CITY OF ALBUQUERQUE

January 15, 2013

Re: North Andalusia DMP and Pond A Grading Plan
Engineer's Stamp date 1-4-13 (E12/D015)

A WEIR SECTION A-A
N.T.S.

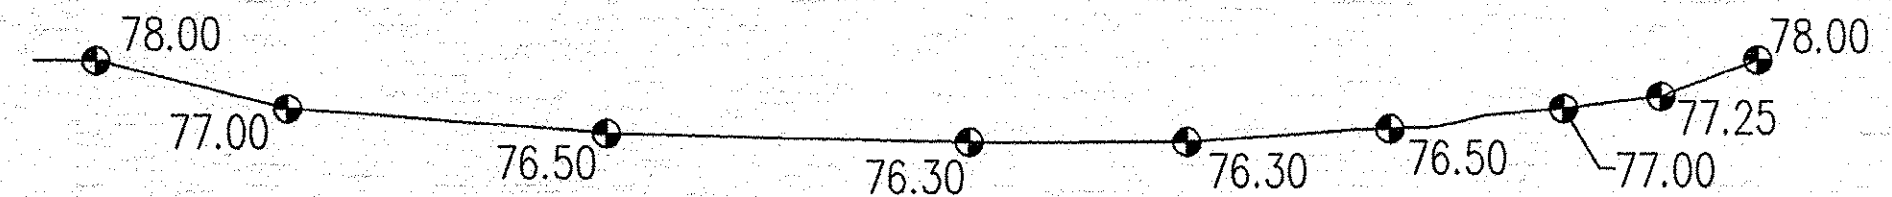
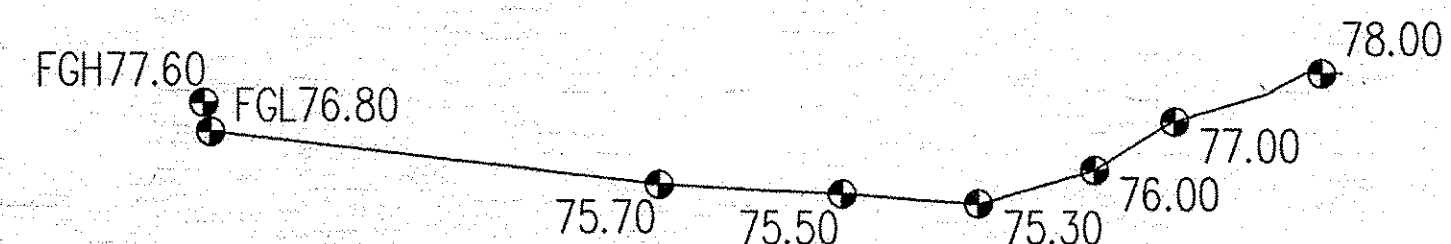
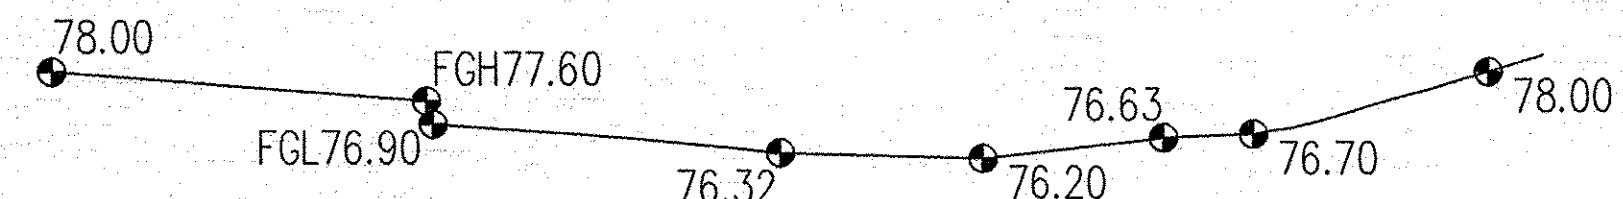
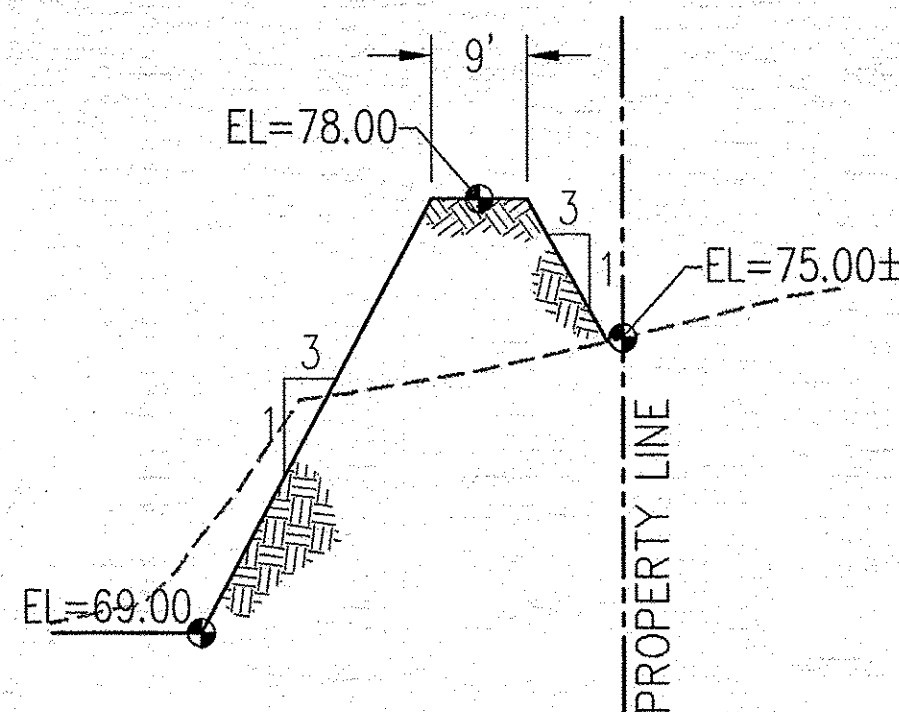
4. In addition, a portion of the spillway is in the MRGCD ROW. Show the Tract 1A property line on weir sections A-A through D-D. MRGCD approval is required.

D OVERFLOW AREA ENLARGED GRADING DETAIL
SCALE: 1" = 30'

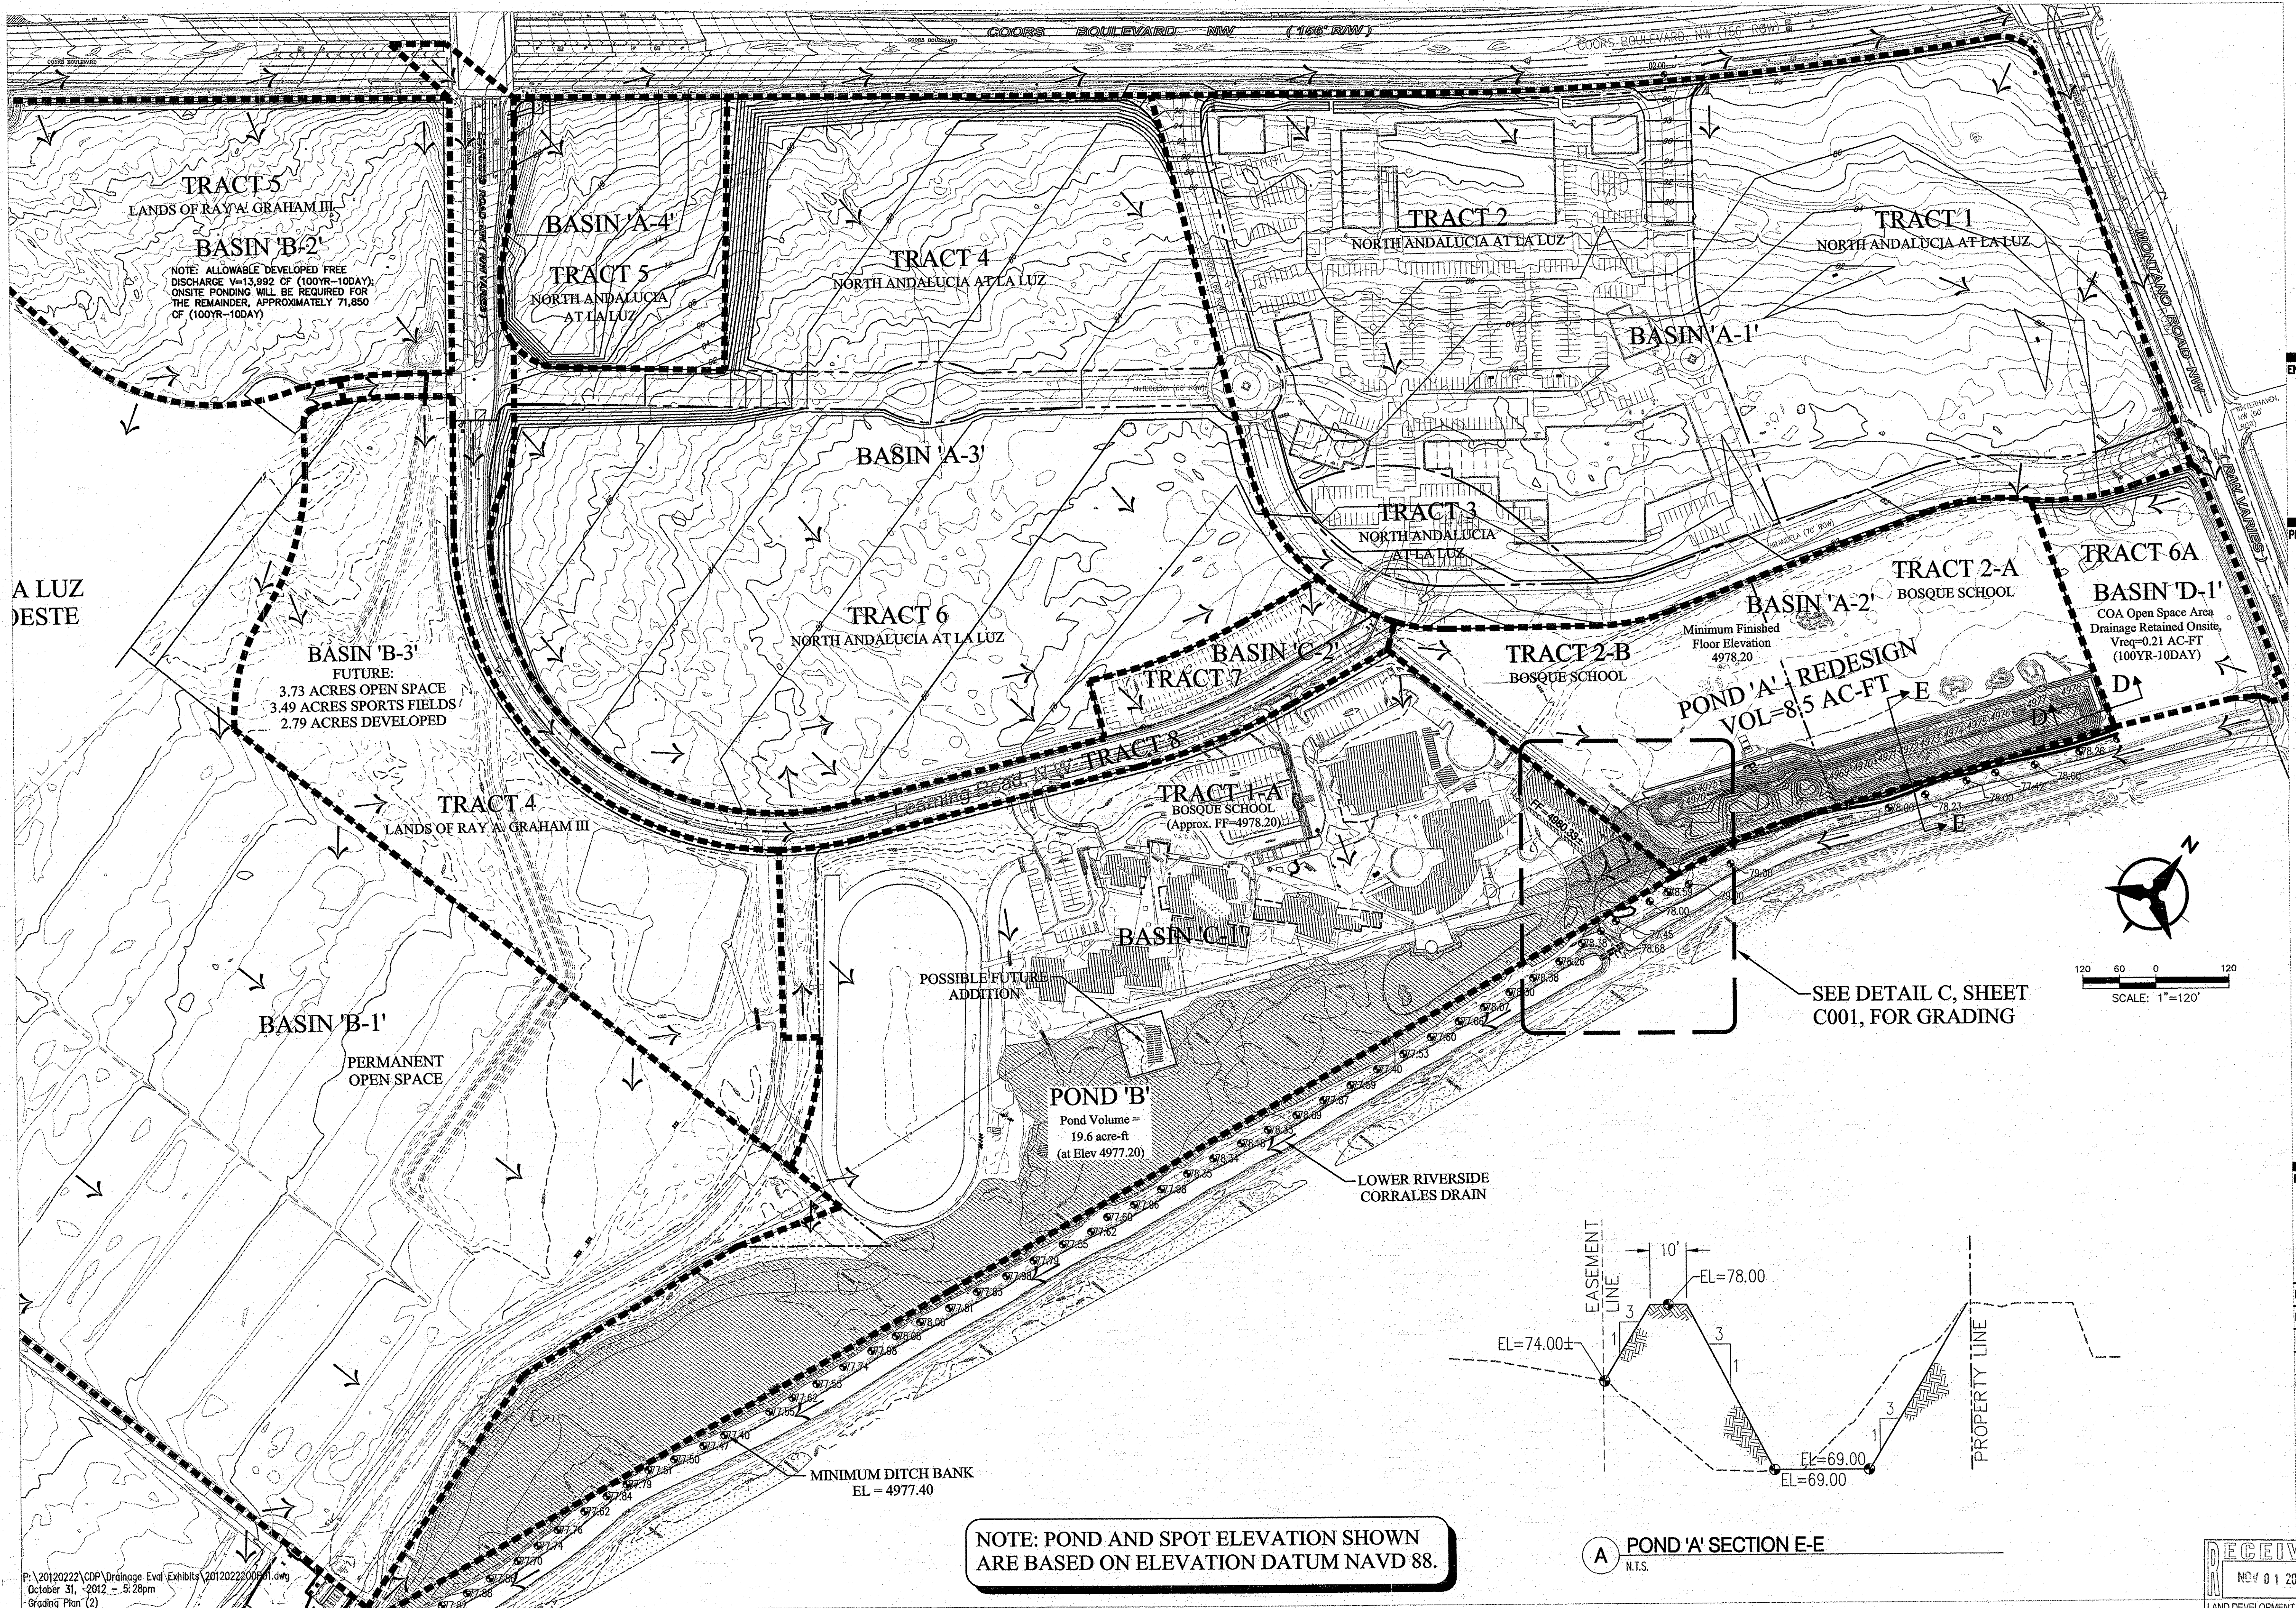
7. The Overflow Area Grading Plan Keyed Note 5 provides instructions to adjust a SAS manhole rim. Add the note "ABCWUA Utility Development must be notified before any work is done to adjust the existing manhole rims due to required drainage modifications. Hydrology can not give approval for work on an ABCWUA system.

**DRAWING NAME**  
 POND 'A'  
 GRADING  
 PLAN

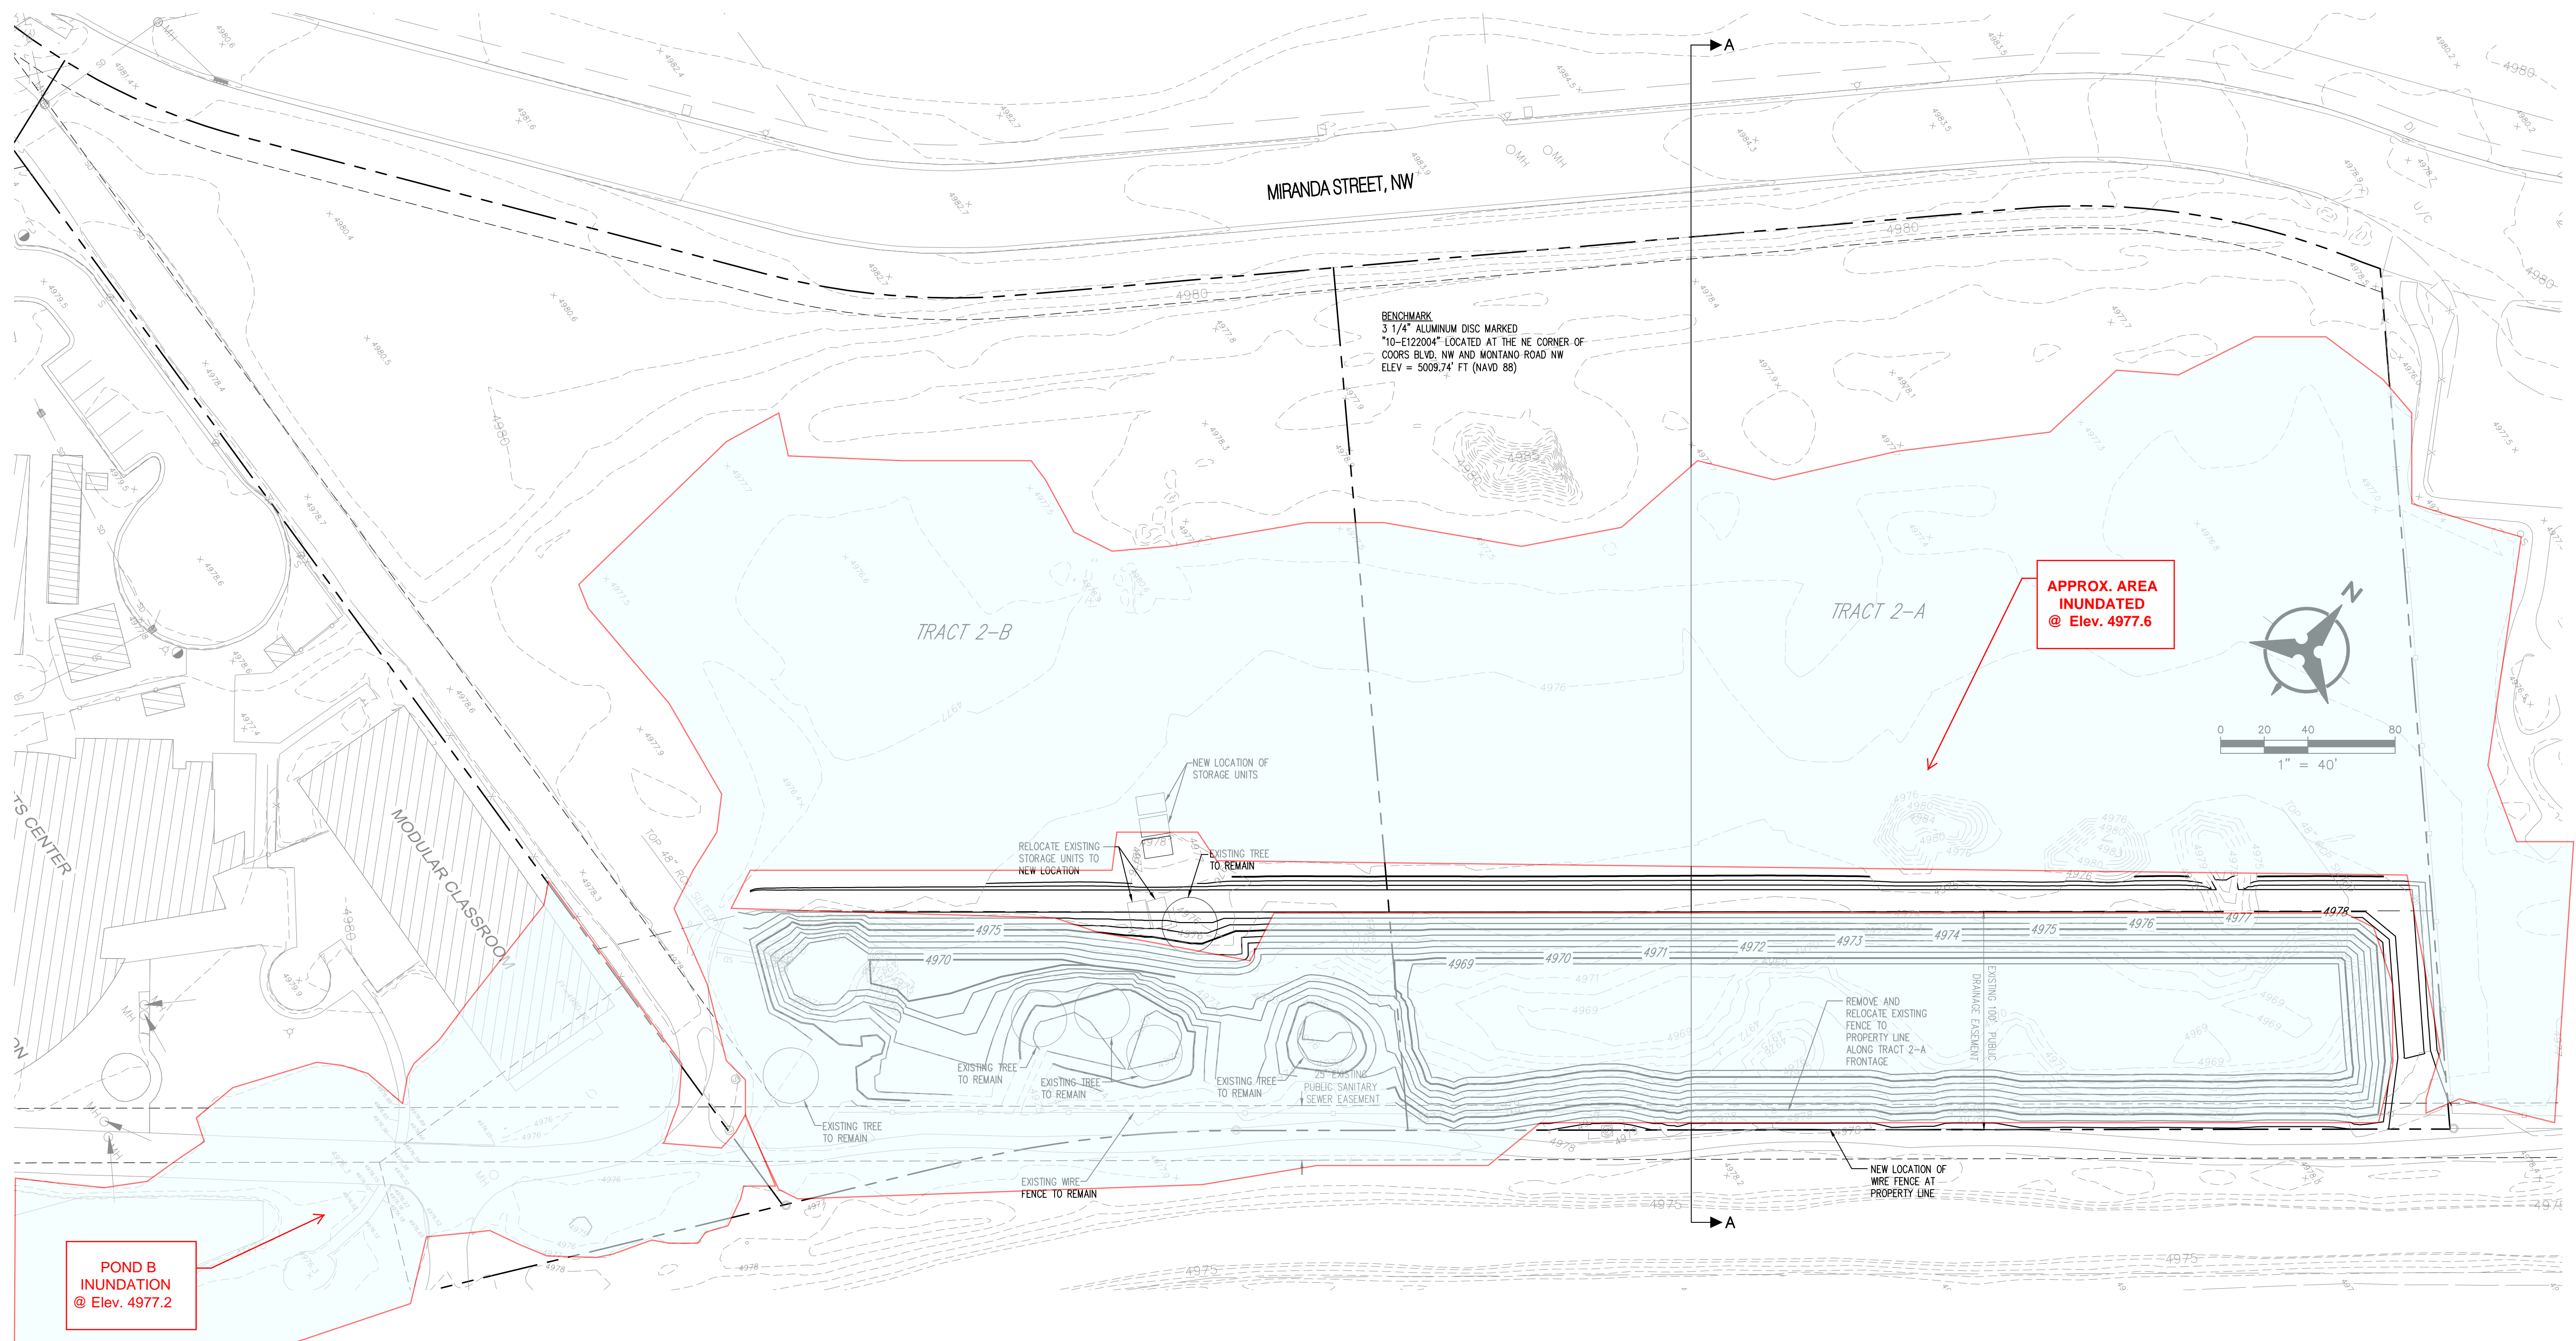
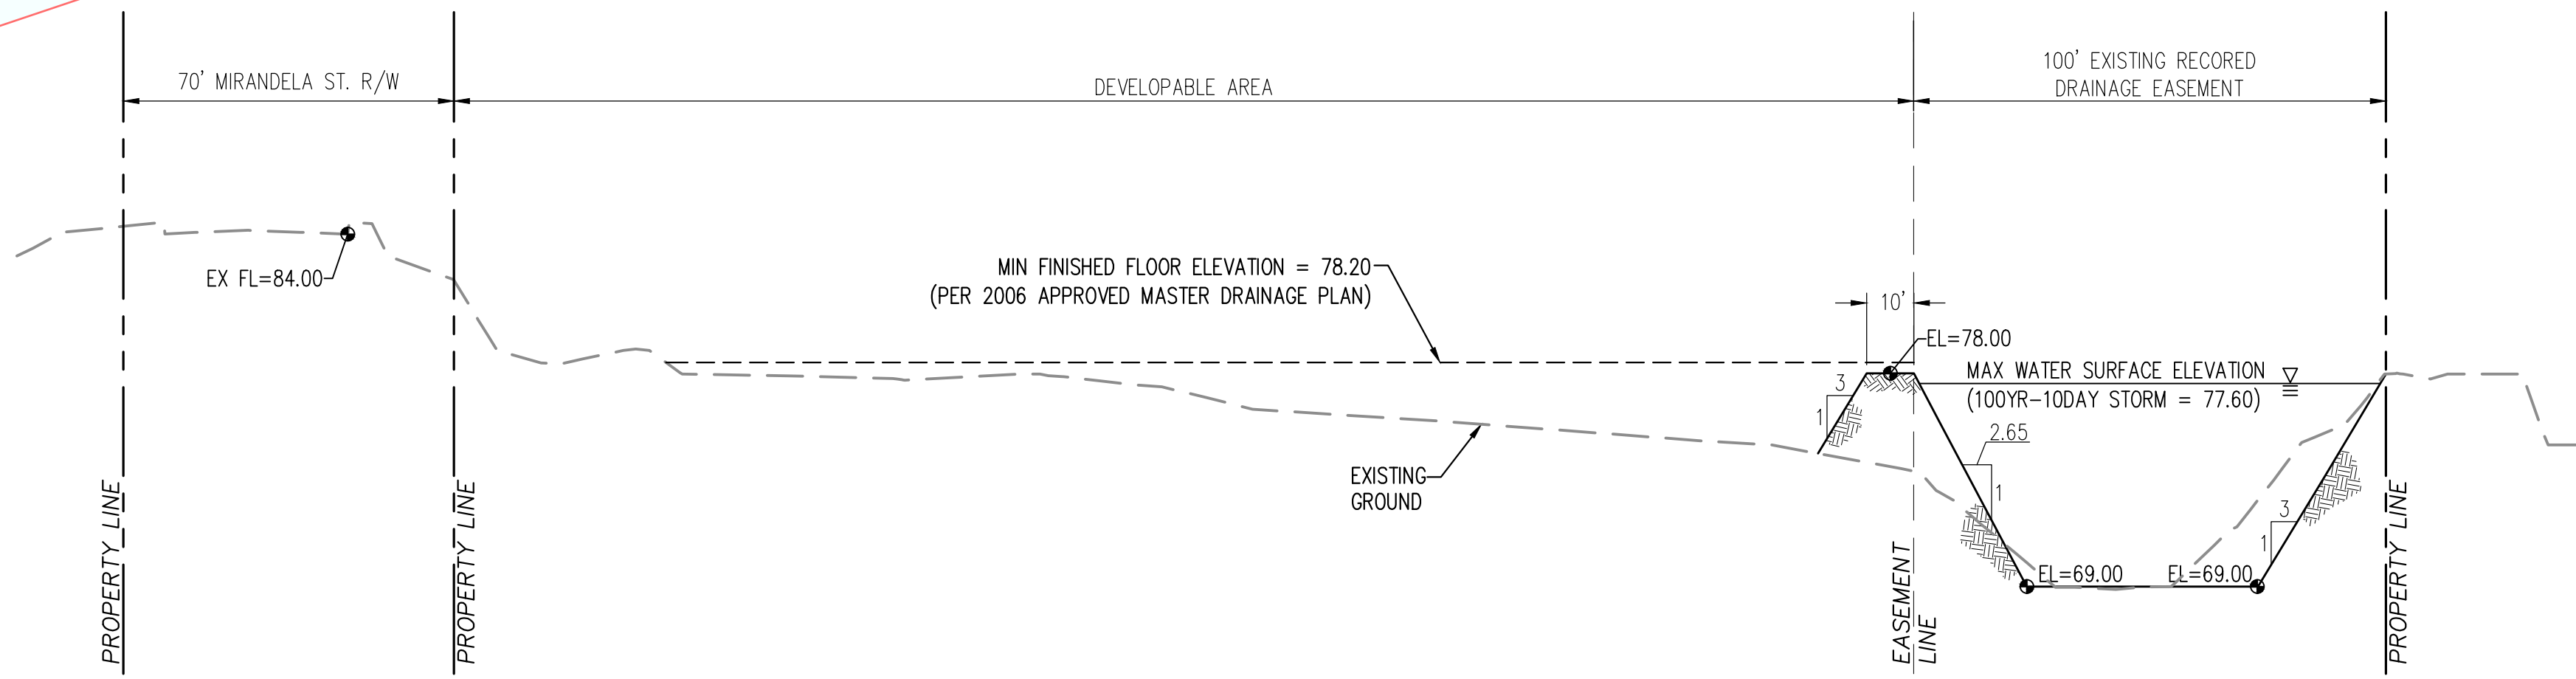
2. Isn't the edge of the Public Drainage Easement on the east property line of Tracts 2-A and 2-B?
3. The proposed WSE of 77 and 77.4 are outside of the Public Drainage Easement on the east side of the pond along Tract 2B at an elevation of about 76.2 and is outside the Tract 1A property line below an elevation of 77. MRGCD approval is required to pond in their ROW.
